FOURSQUARE AT STERLING RANCH EAST FILING NO. 1

UTILITY CONSTRUCTION PLANS

NOVEMBER 2022

TITLE SHEET

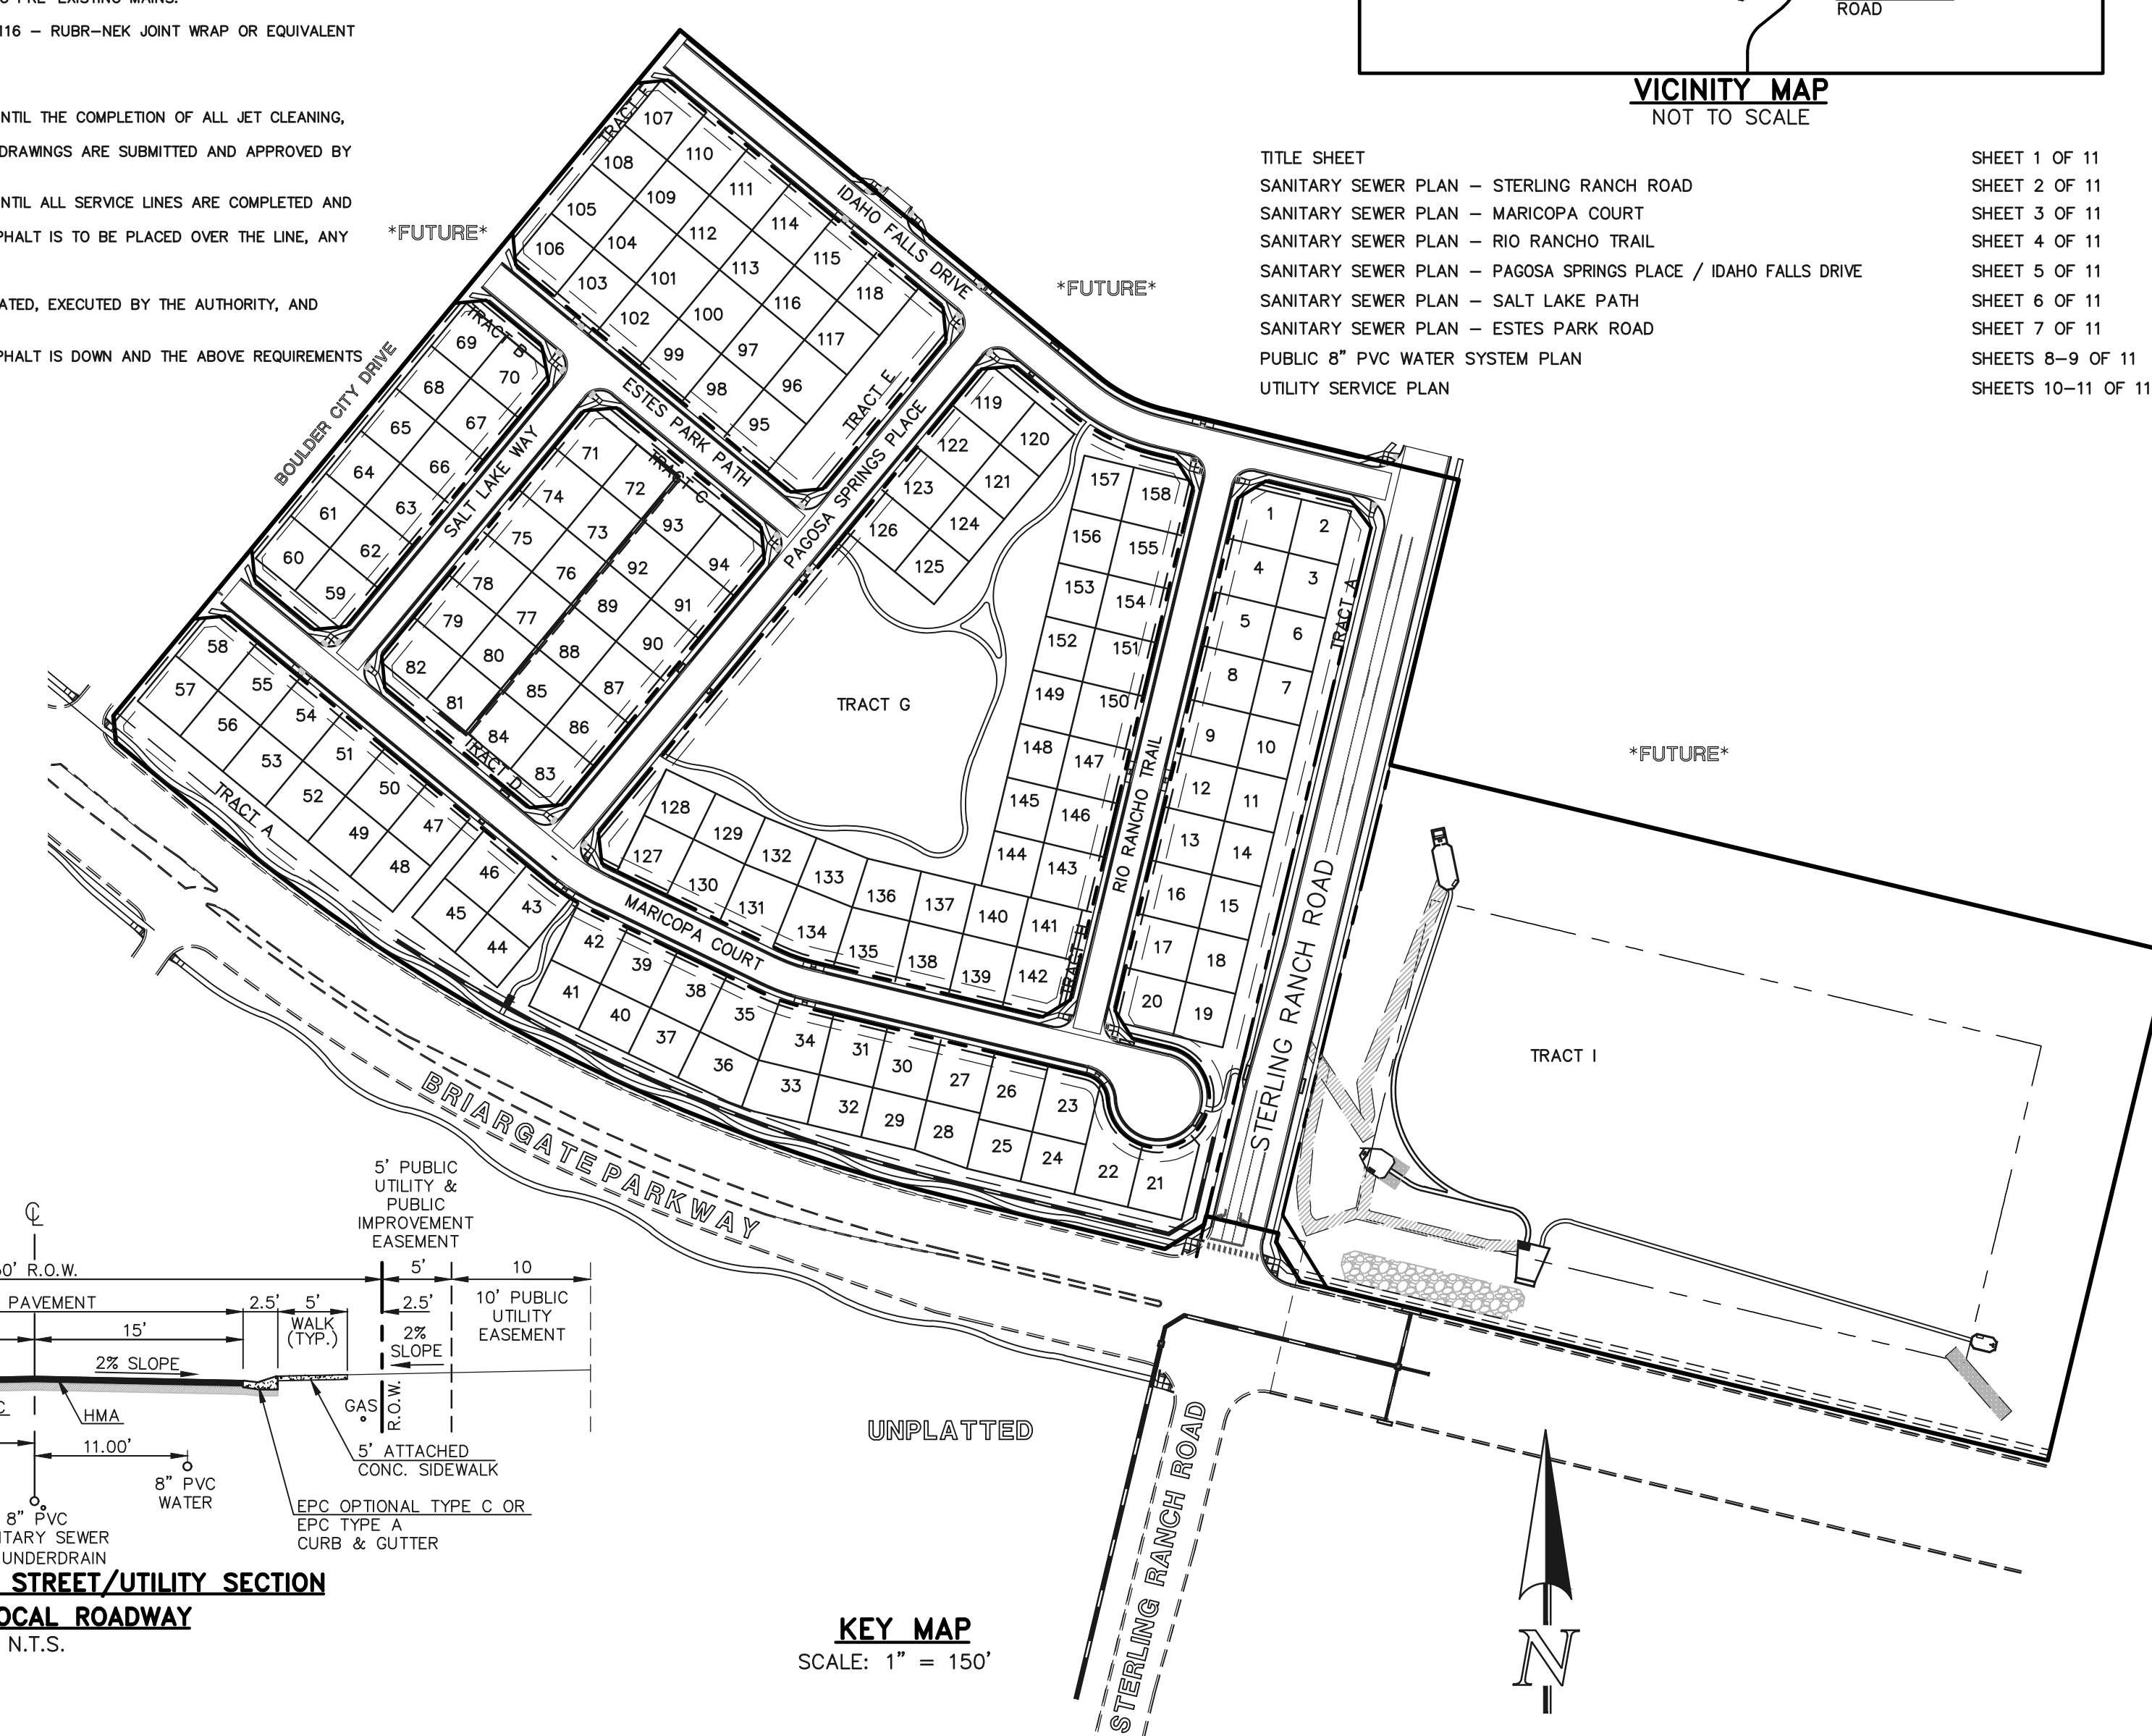
Unresolved, Add information for Basis of Bearings & Benchmarks
